15 March 2022

Springvale Coal Mine Longwalls 428-432 Extraction Plan

I refer to Centennial's application in March 2021 for the Department's approval of an Extraction Plan for the proposed Longwalls 428 – 432 at the Springvale Mine.

Figure 1: Centennial's Amended Mine Plan

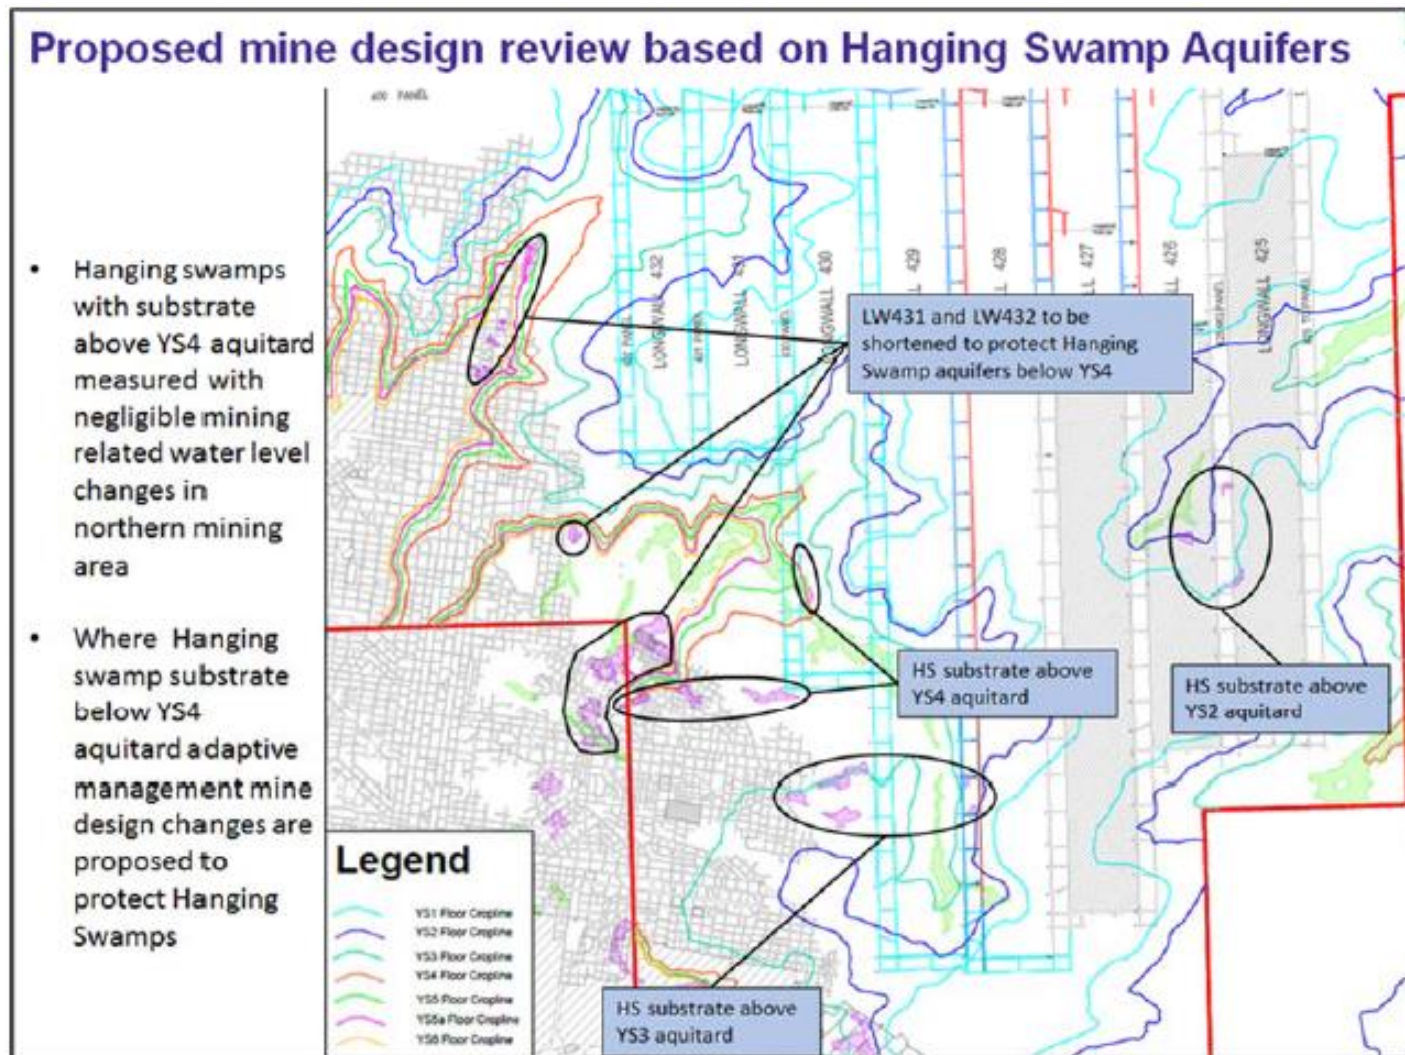
Condition	Details
1	Centennial Springvale must limit the commencing position of longwall LW 430 to cut-through 11, as shown on Figure 1 in Attachment 1. Secondary extraction south of cut-through 11 is not permitted under this approval.
2	Centennial Springvale must implement its commitment to shorten longwalls LW 431 and LW 432 as identified in its RTS report.
3	Centennial Springvale must implement its commitments regarding additional monitoring recommended by the Springvale Independent Monitoring Panel as set out in its Supplementary RTS, dated 9 December 2021
4	Centennial Springvale must within three months of the date of this letter of approval, provide the Department with: a) revised drafts of its Swamp Management Plan, Biodiversity Management Plan and Water Management Plan which include the additional monitoring required under condition 2 and revisions to Trigger-Action-Response-Plans as recommended by the Springvale Independent Monitoring Panel; and b) an updated Extraction Plan and sub plans that reflect the approved limits of LW430 – LW432;
